Abert Ranch Subdivision  
Transportation Memorandum  
(LSC #164890)

RE: Abert Ranch Subdivision  
El Paso County, CO  
Transportation Memorandum  
LSC #164890

# Preliminary Plan for ABERT RANCH SUBDIVISION

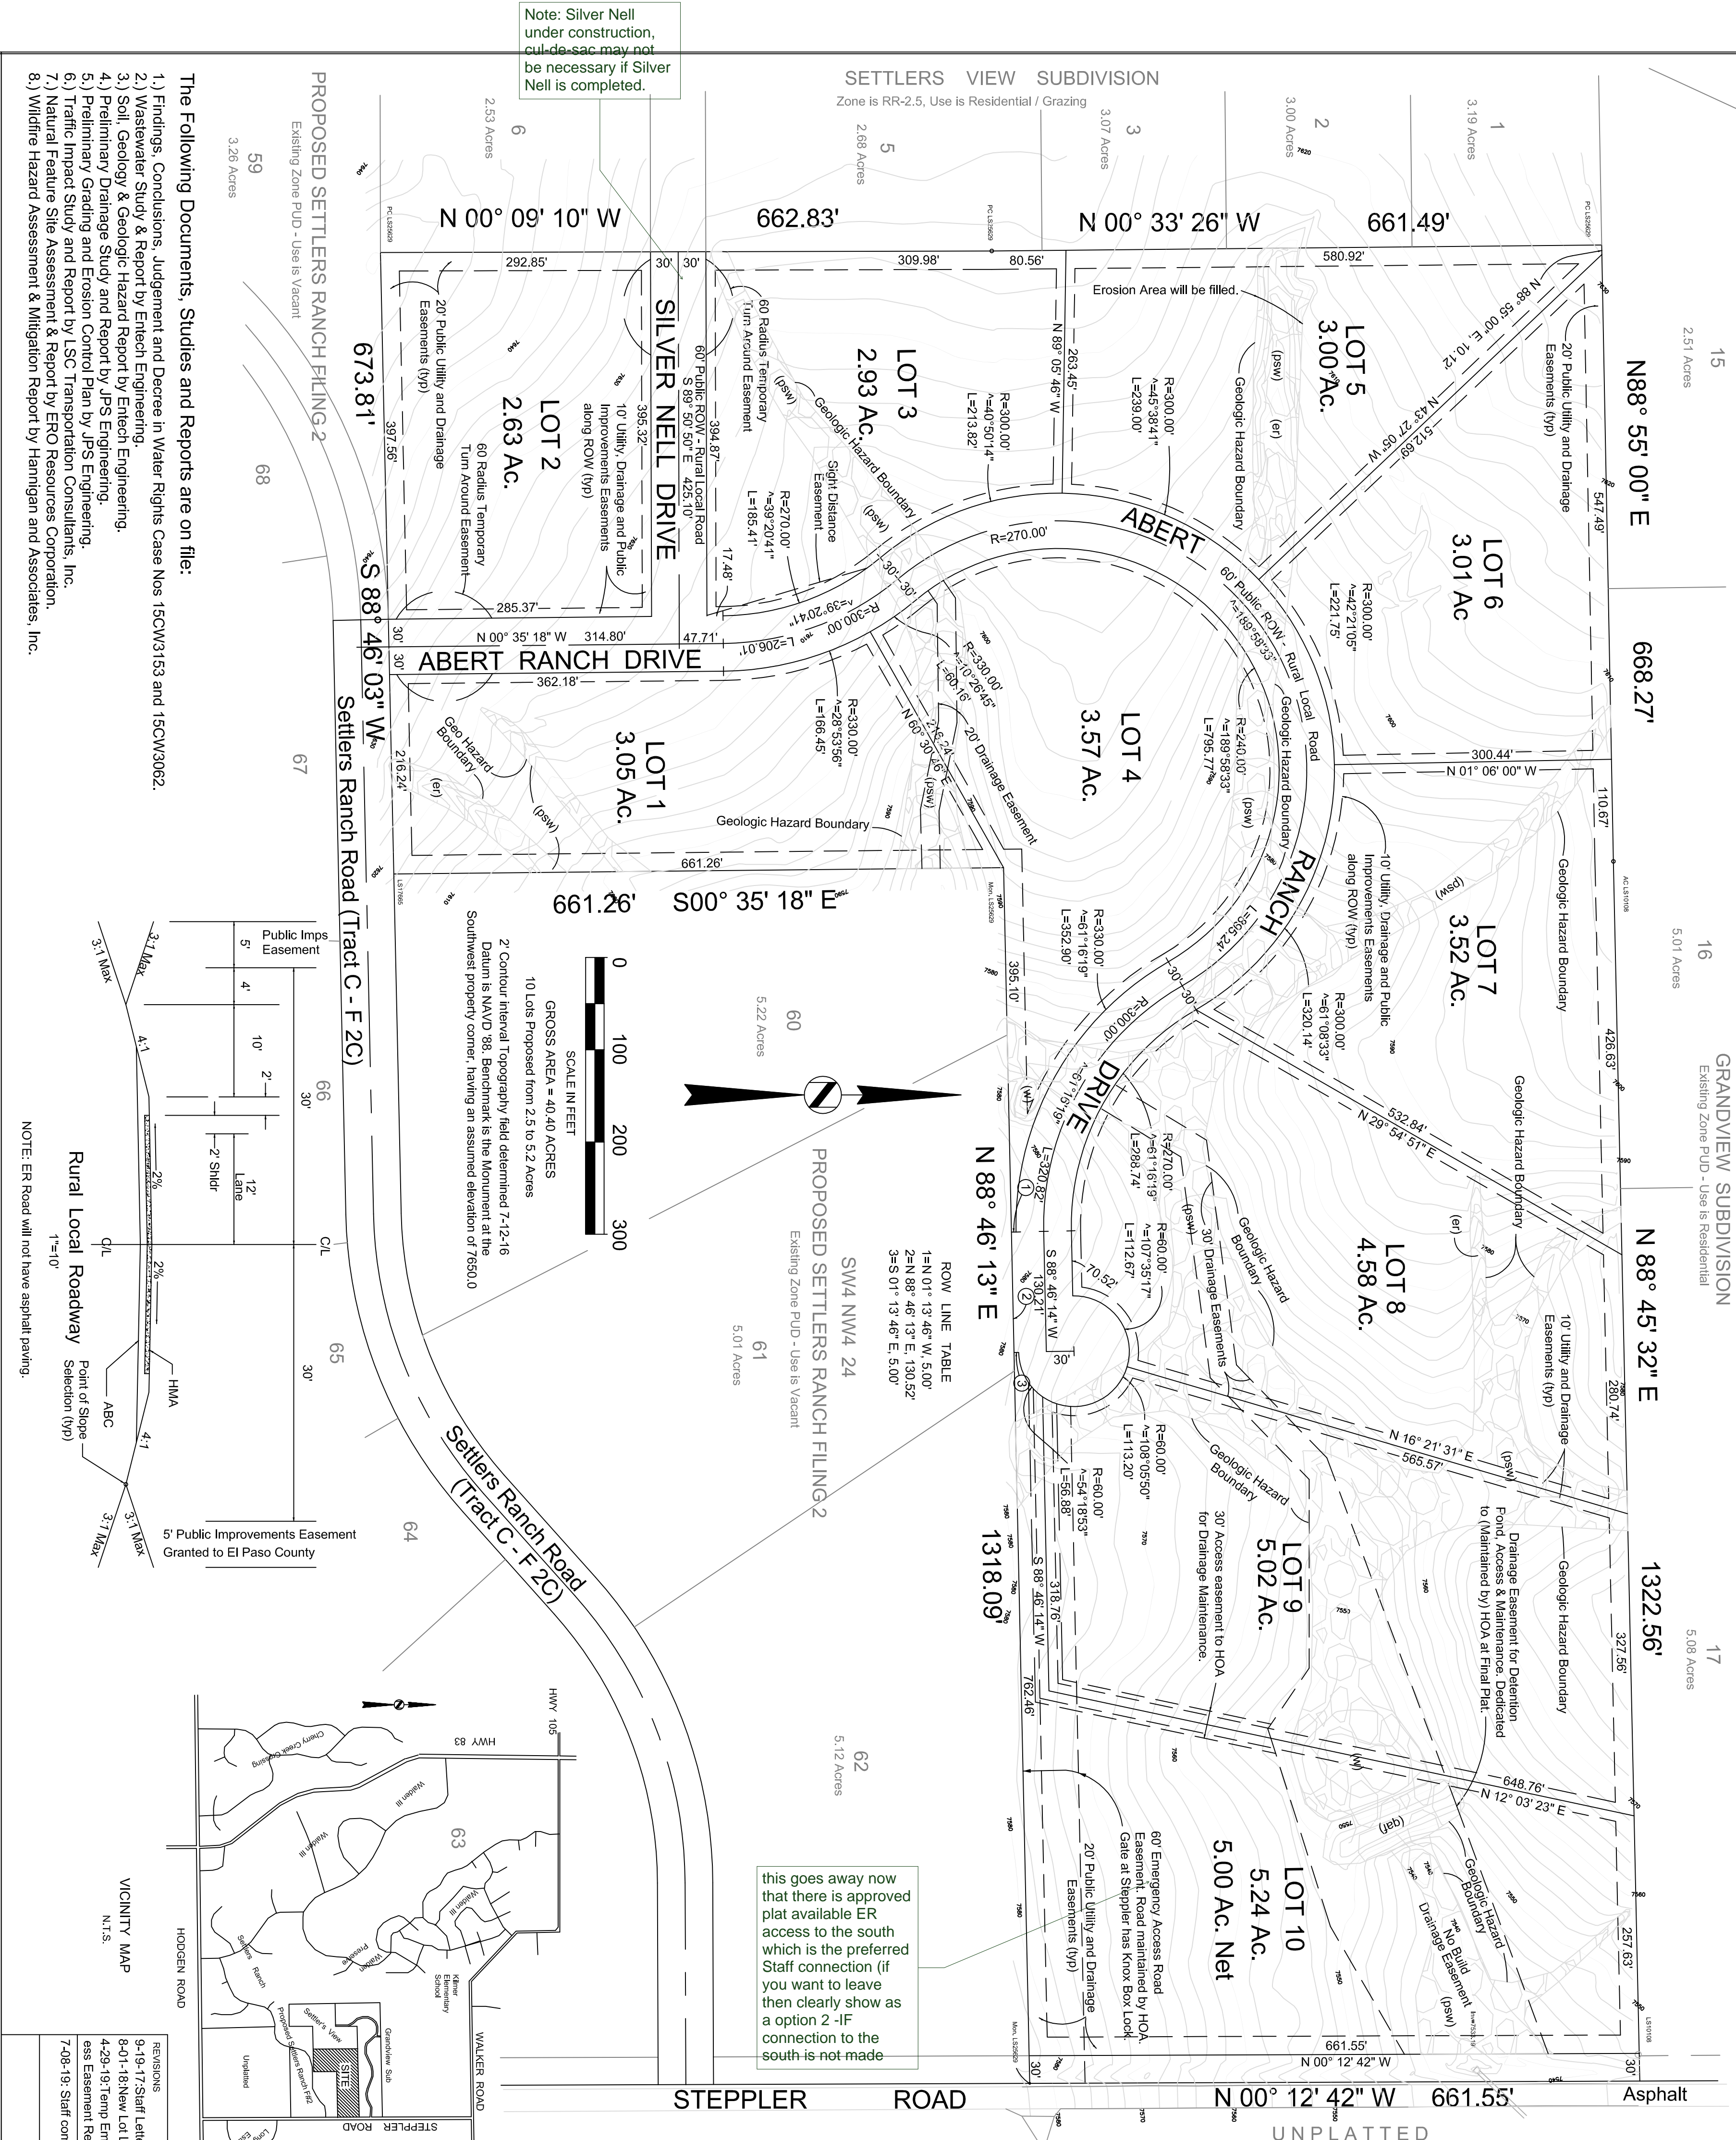
Per ECM Table 2-5, minimum centerline radius is 300 ft. Revise or submit a deviation request.

Provide a summary for Silver Nell Drive and Albert Drive. The temporary access from Albert Drive to Steppler Road is required. This may need to be the primary access to the lots until the Silver Nell/Albert Drive connection is made. If the Silver Nell/Albert Drive connection is constructed in conjunction with Settlers View Subdivision, then the temporary access will be used as a secondary access for emergency access only. The emergency access will be removed once the Albert Drive/Settlers Ranch Road intersection is constructed.
